DELEGATED DECISION TO DETERMINE PLANNING APPLICATIONS

Reference No:	2025/62/92748/E
Site Address:	Birstall Primary Academy, Chapel Lane, Birstall, Batley, WF17 9EJ
Description:	Erection of security mesh fencing atop existing sandstone wall, installation of 1 automated vehicular sliding gate to staff car park, formation of opening within existing masonry wall structure and installation of 1 pedestrian access gate (within a Conservation Area)
Recommending Officer:	Elenya Jackson

DECISION – Conditional Full Permission

DRAWING NUMBER	2025.050.PL06
----------------	---------------

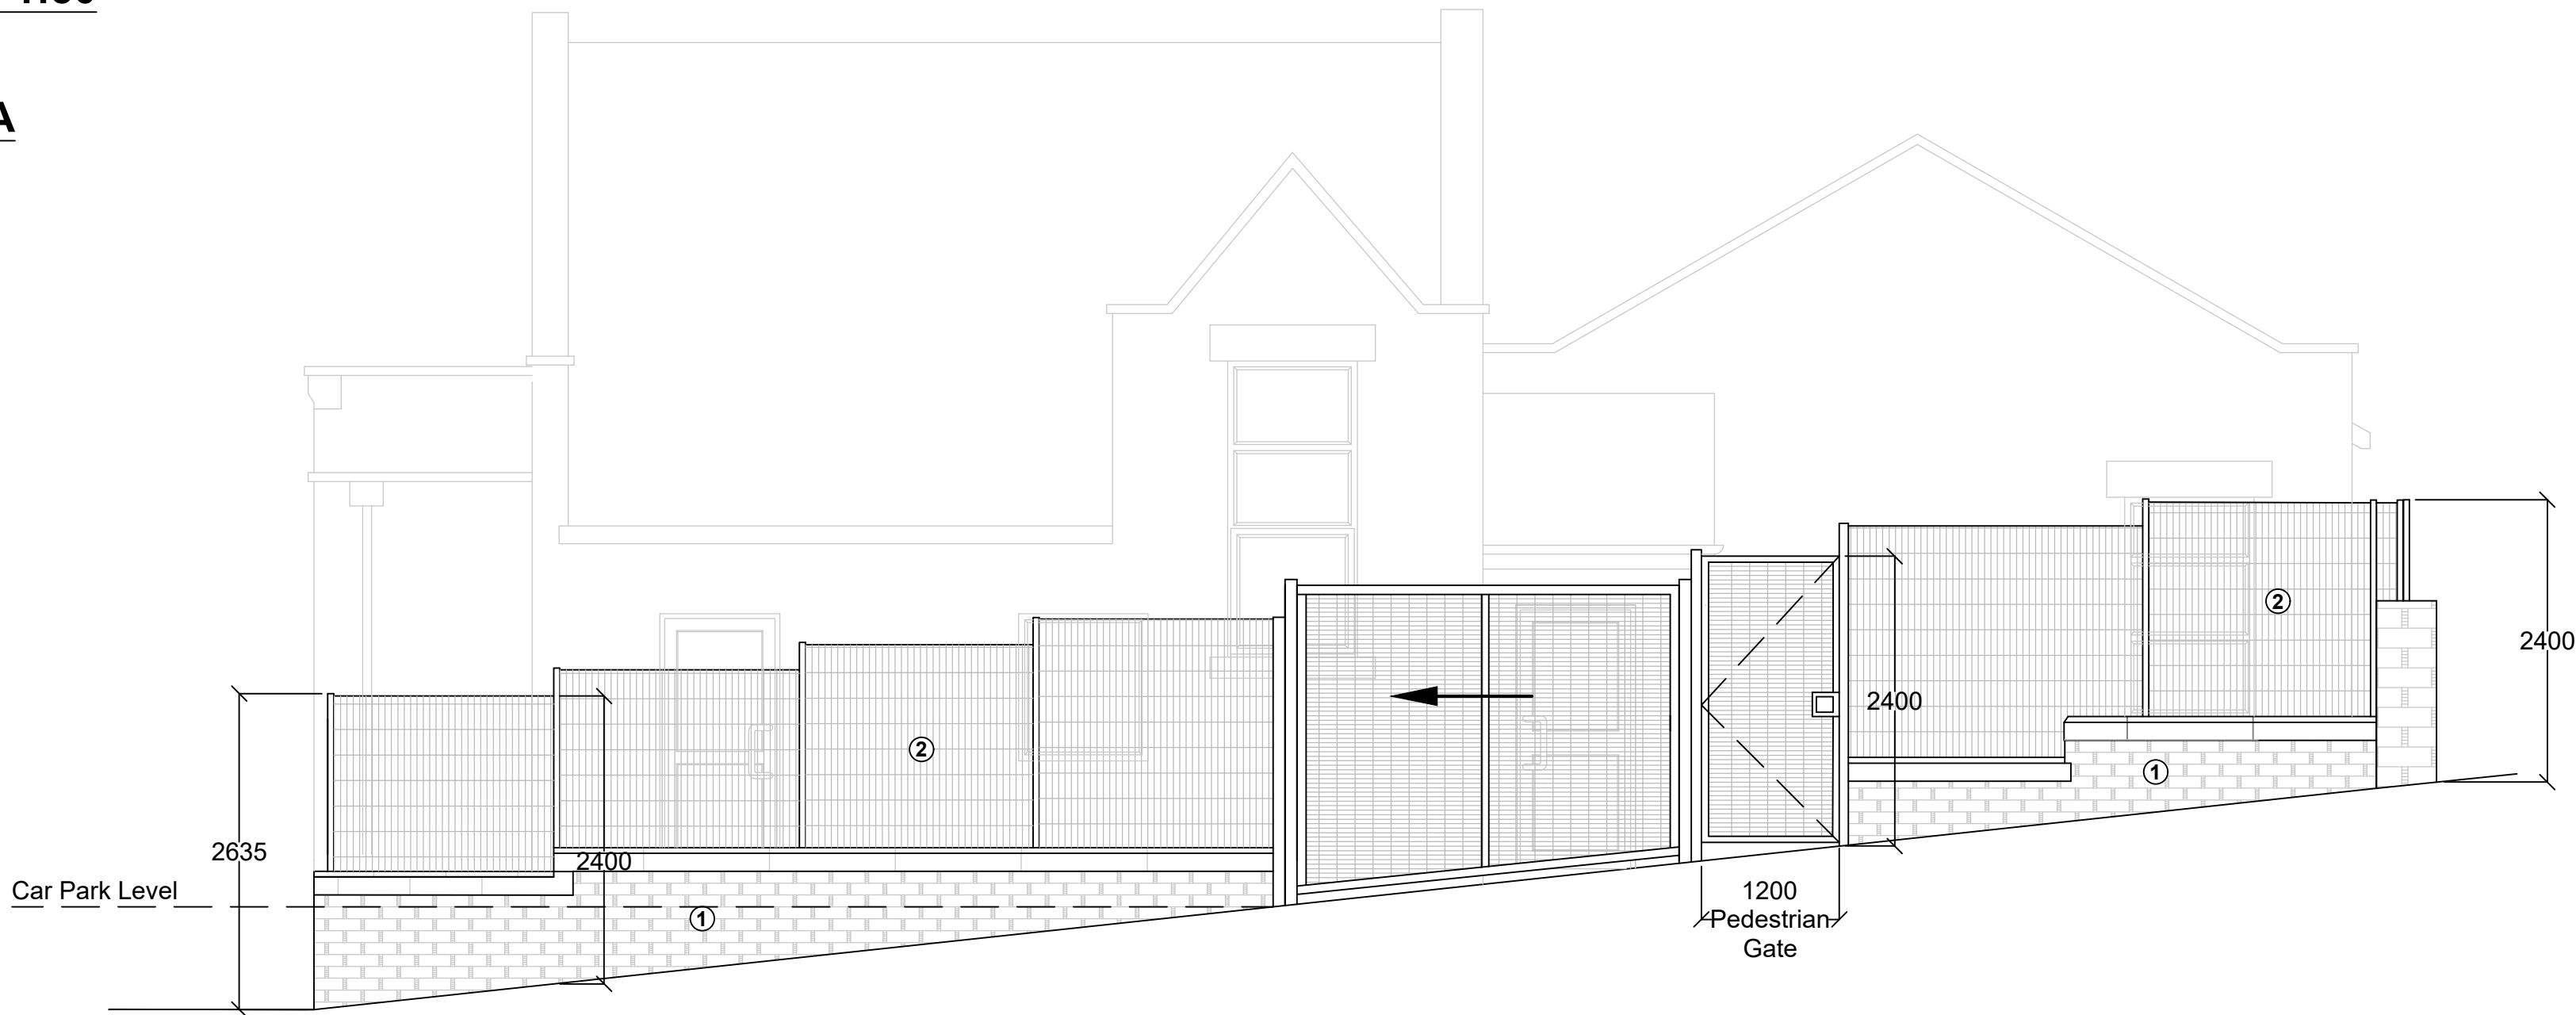
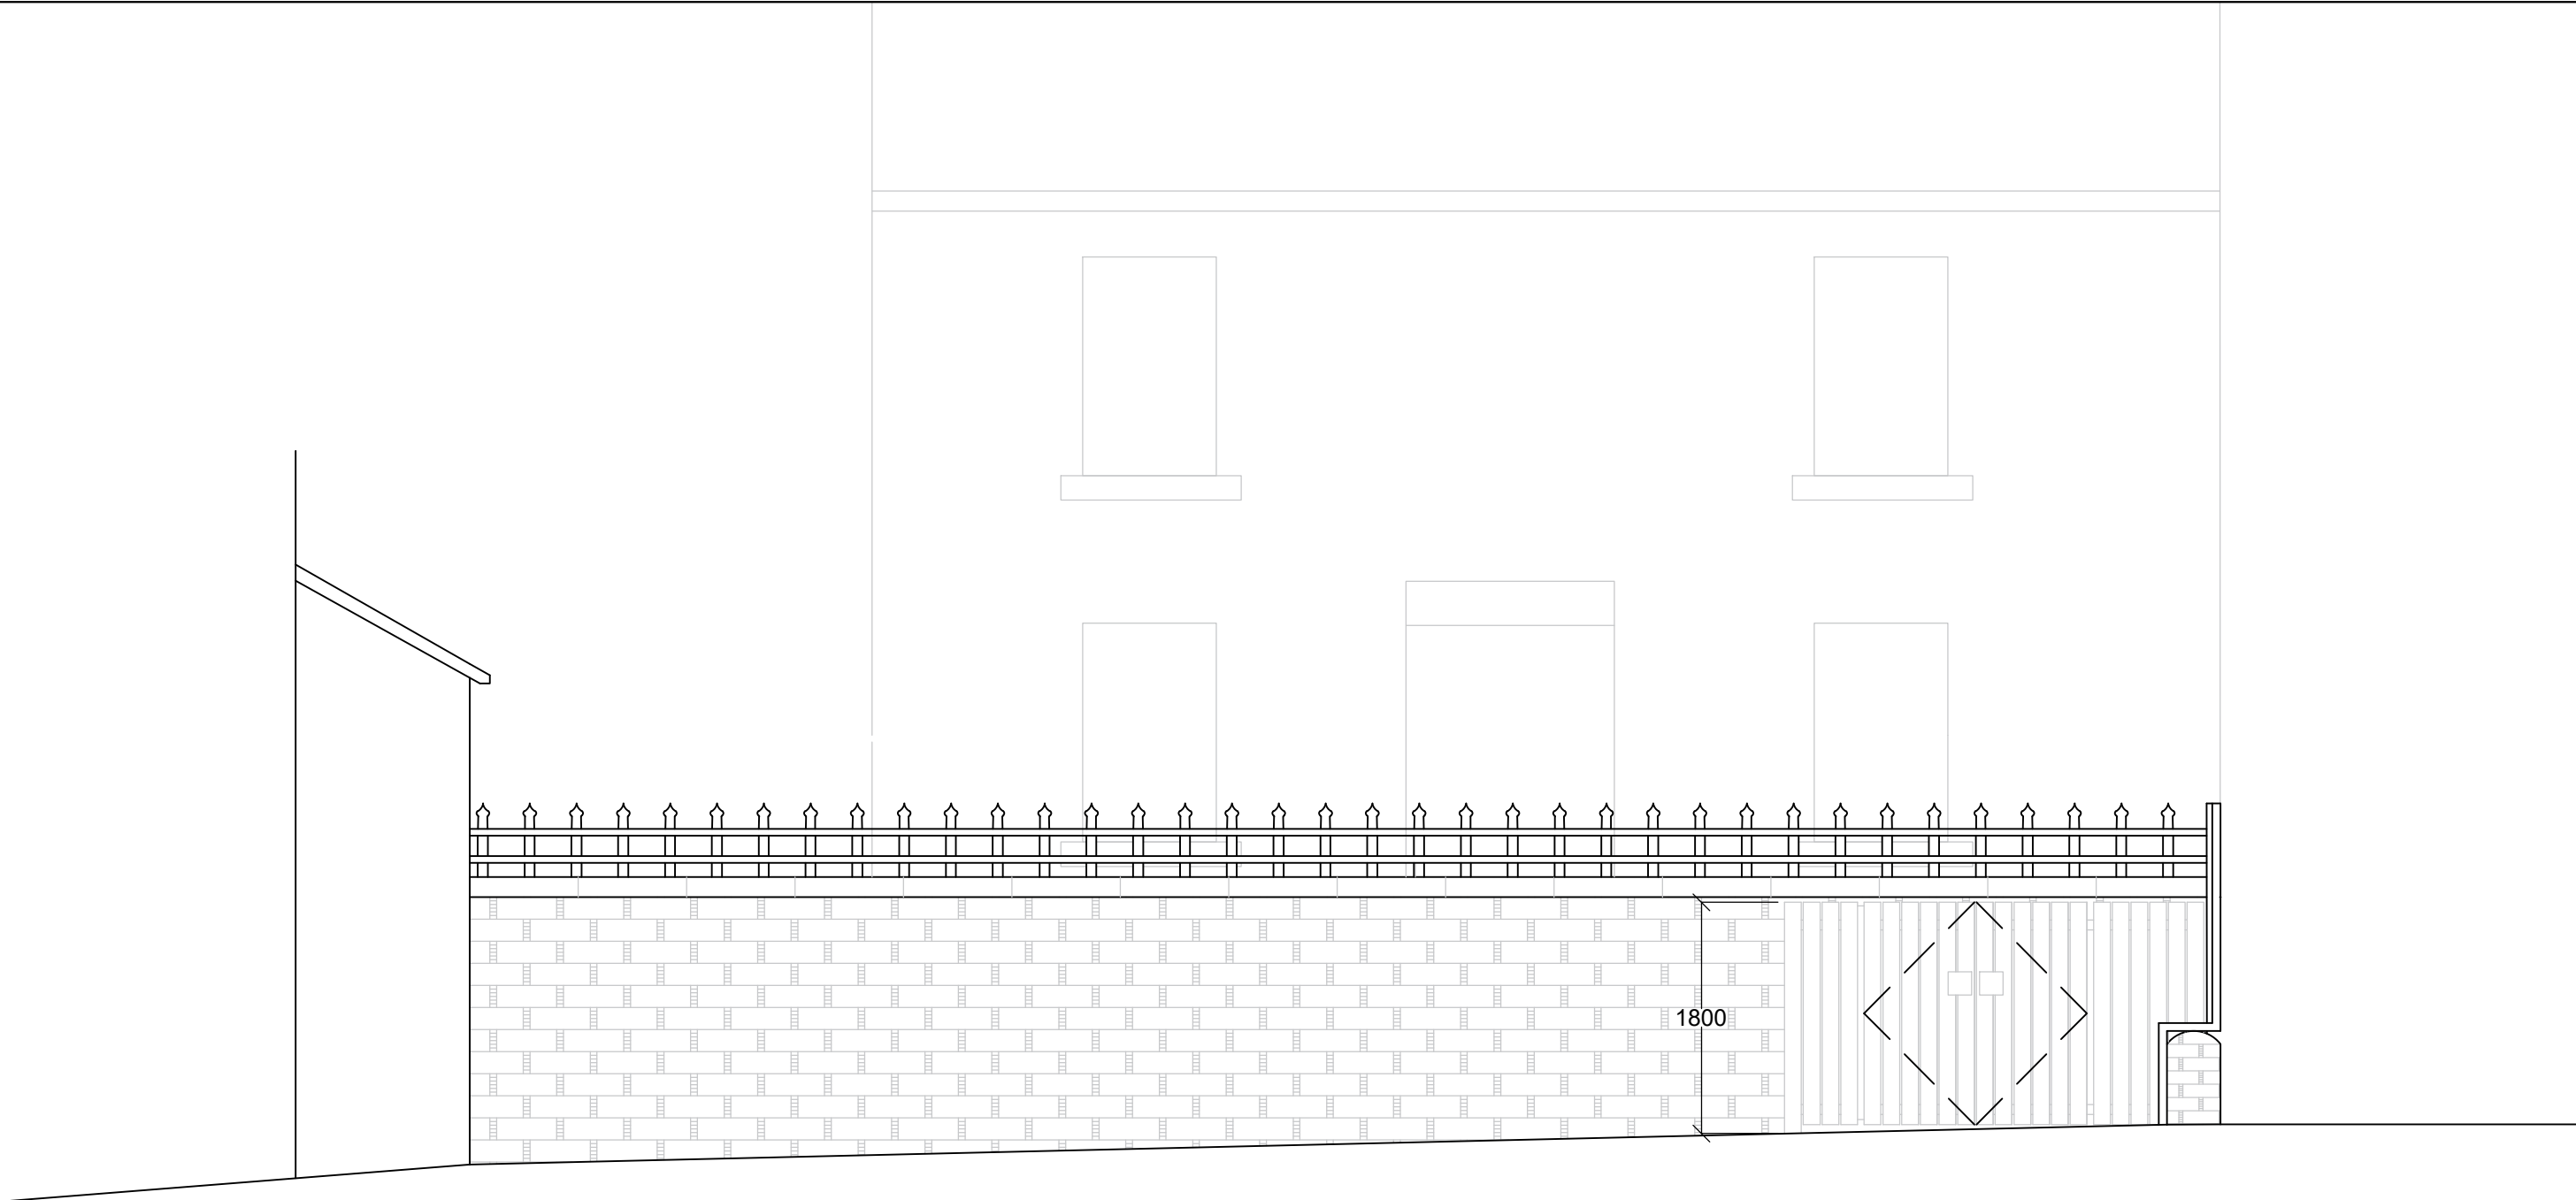
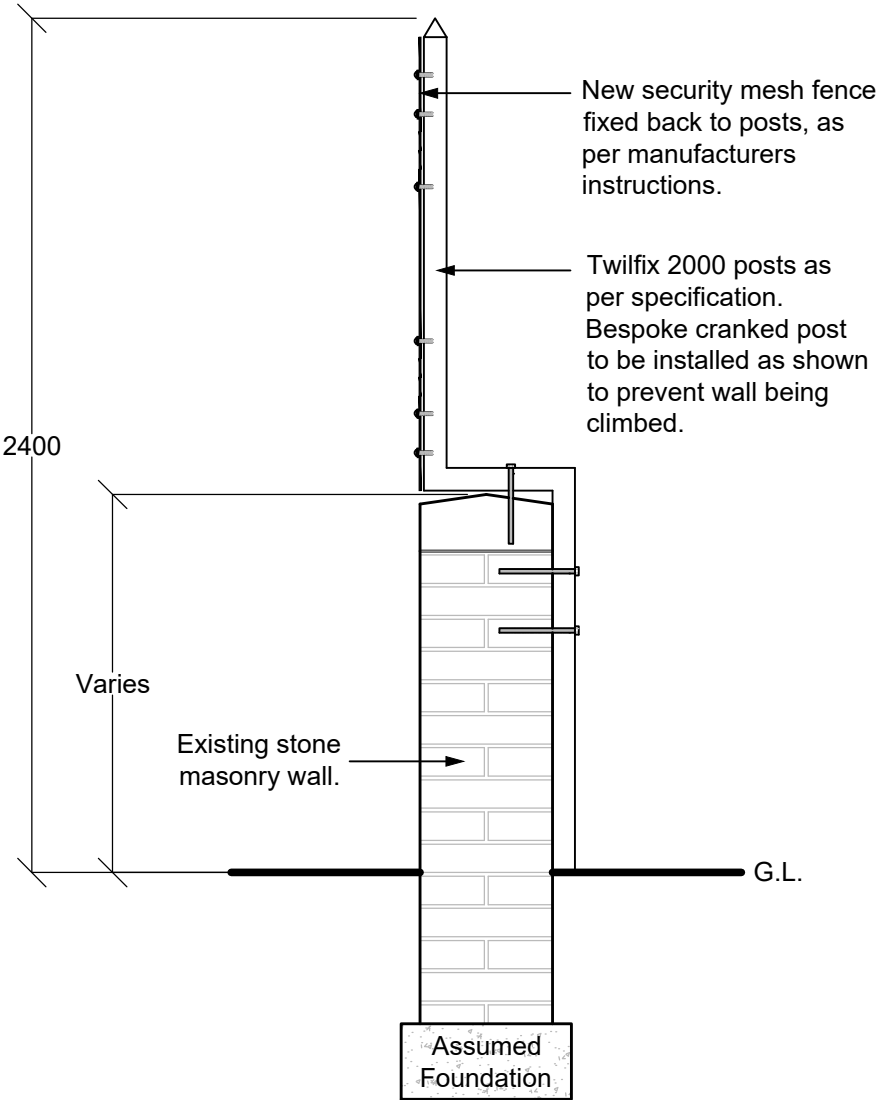
The proposed fence would sit above the existing boundary wall and would make the total height of the boundary treatment along this elevation 2.6m. Due to the site being located on a corner plot in the street scene, the fence would be visible from public vantage points

In terms of impact on the visual amenity on of the Conservation area, Conservation and Design Officers were informally consulted and concluded that the fence would cause less than substantial harm to the significance of the wall by introducing a tall and visible, structure on top of the wall; however, the fencing is not a solid structure and would be visually permeable which would lessen its impact in terms of detracting from the appearance of the host building and its impact on the character of the area. It is not considered at this time that the works would cause substantial harm.

In terms of the finishing colour of the fence, it is considered that Green would decrease the visibility of the fence and would be in keeping with existing boundary treatment in the vicinity. Officers consider it appropriate to add a condition requiring the fence to be removed should the use of the site cease.

3. The colour finish of the fencing hereby approved shall be finished in green and shall be retained for the lifetime of the development.

4. The hereby approved fence and associated works shall be removed in its entirety prior to the expiration of 3 months form the date when the property ceases to be in use as a primary school.

DRAWING NUMBER  
2025.050.PL04

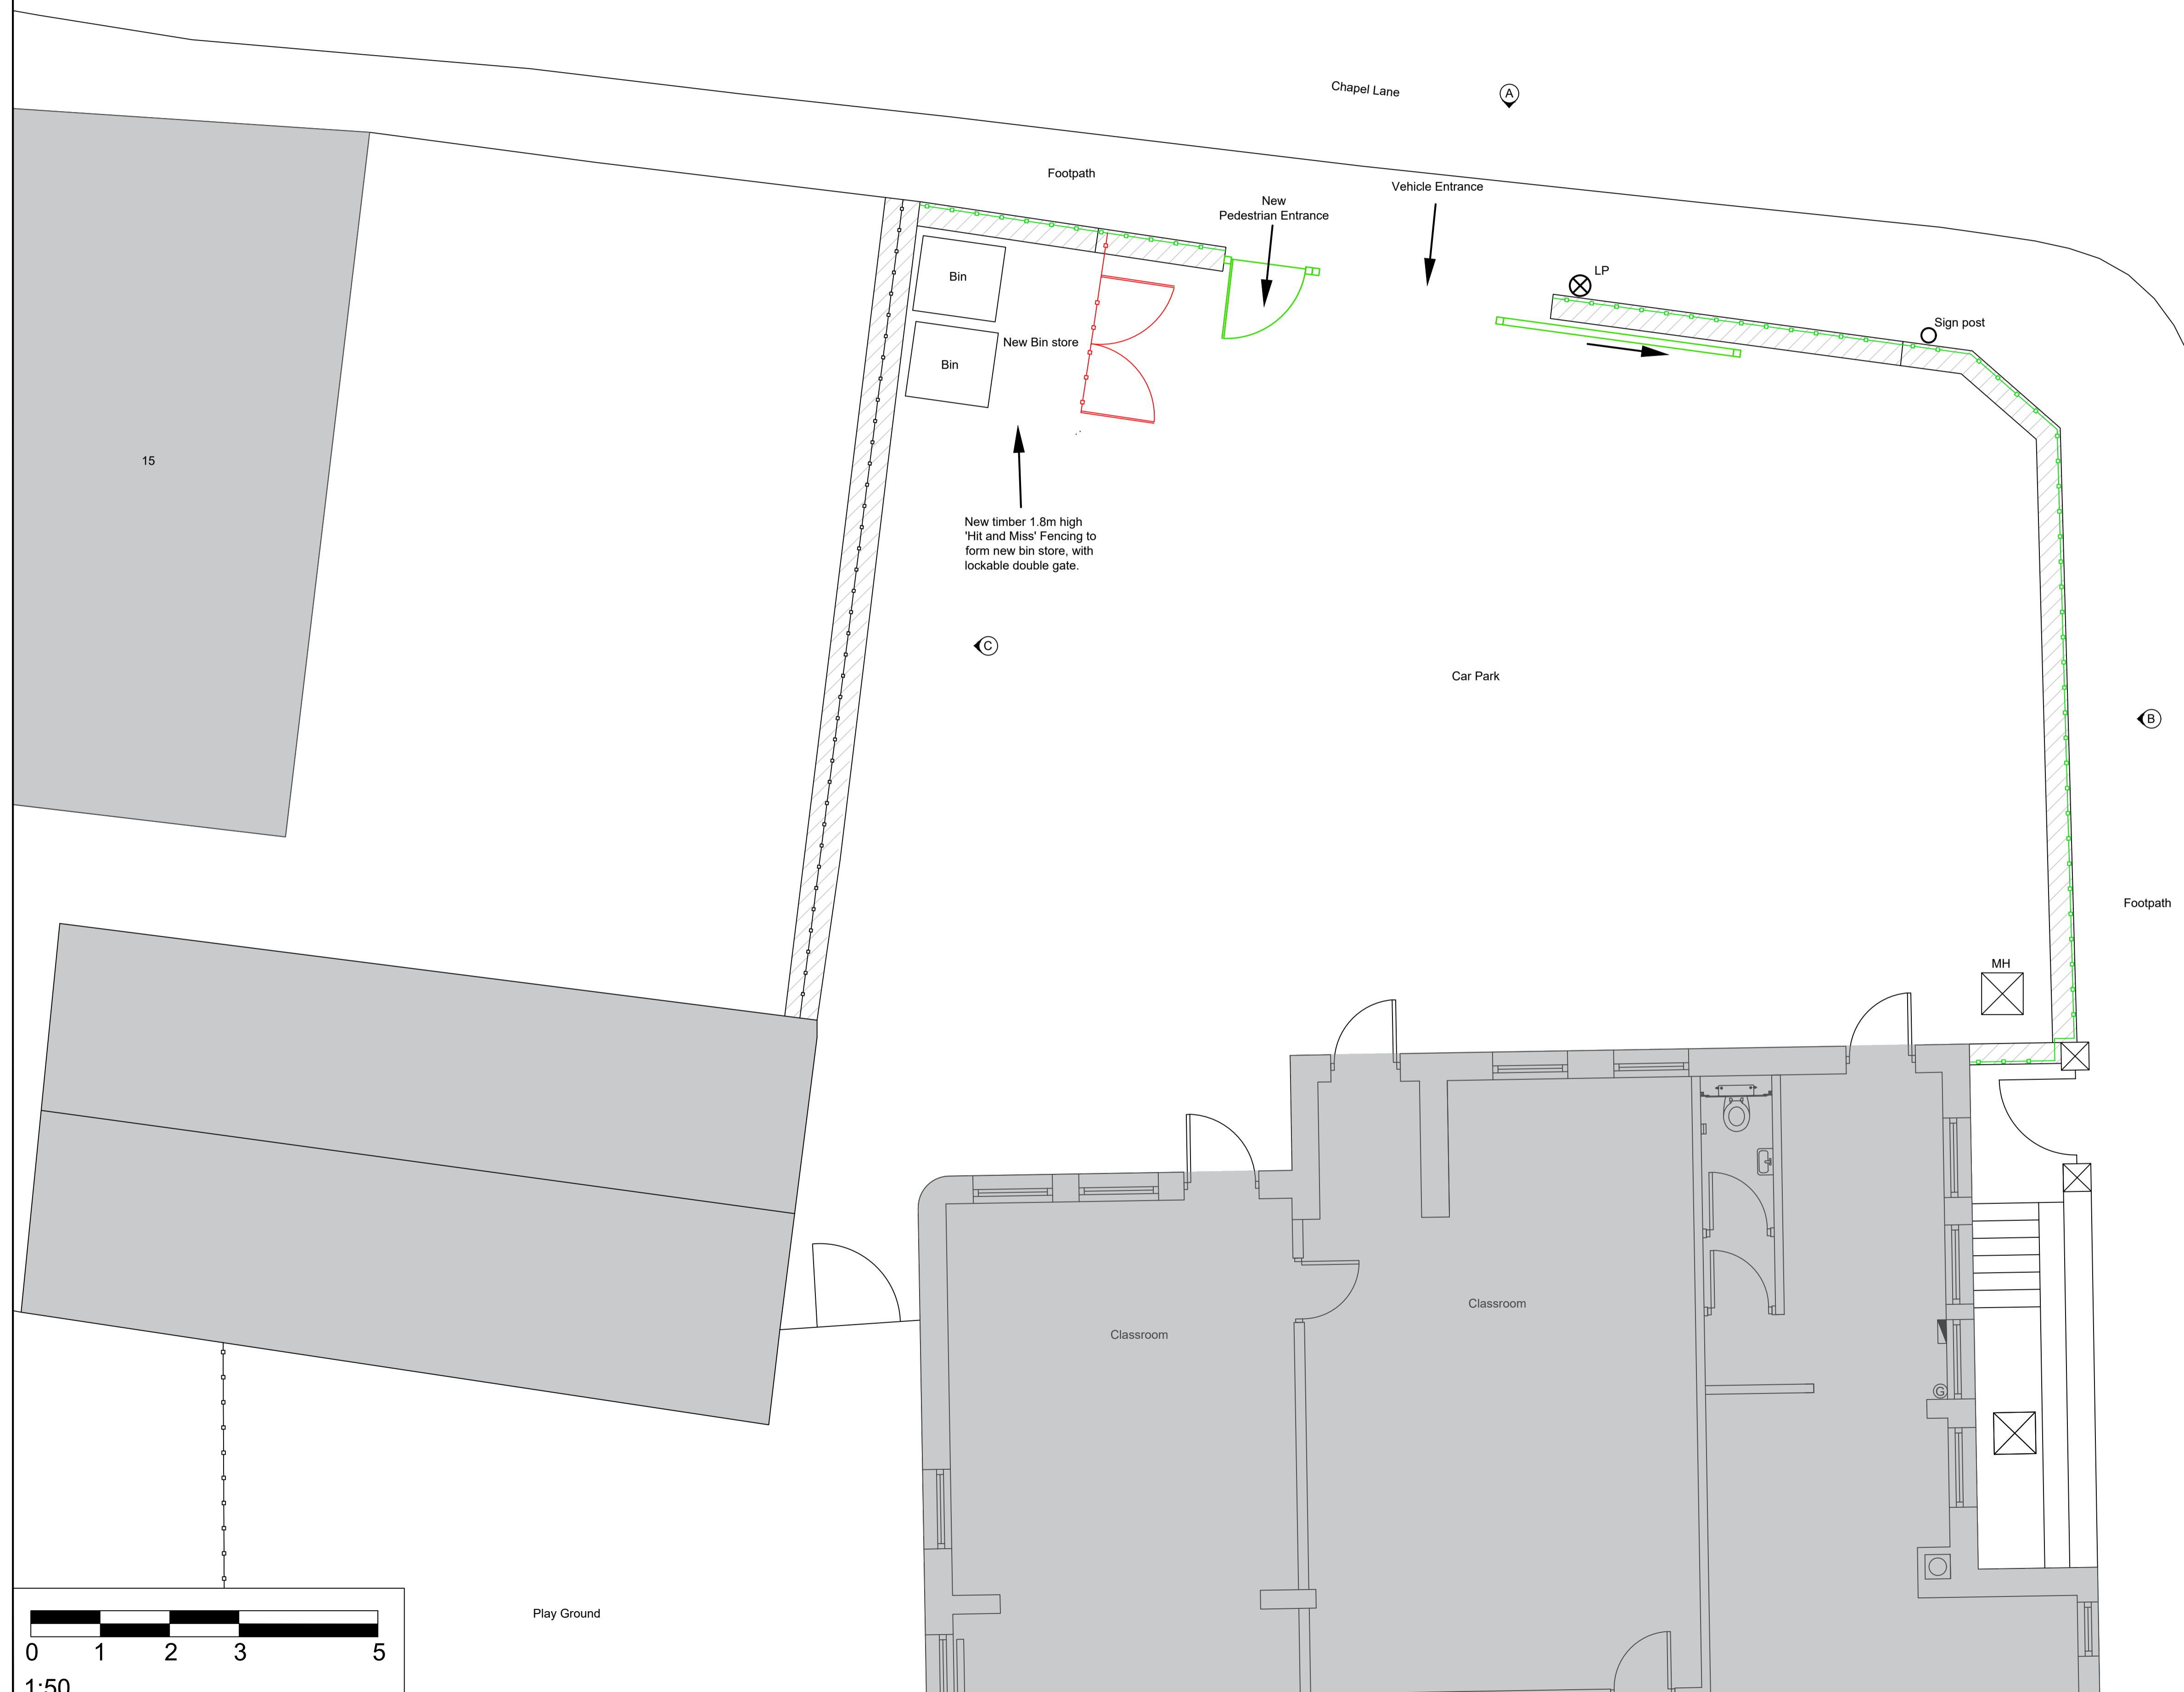
In terms of highway safety there are no highway issues as fencing would not impact the vehicular access of the site and there are substantially sized pavements which would result in the fencing not intercepting the visibility splays onto chapel lane. As such, the proposal would meet the aims of Policy LP21 of the Kirklees Local Plan with respect to highway safety and advice in Chapter 12 of the National Planning Policy Framework.
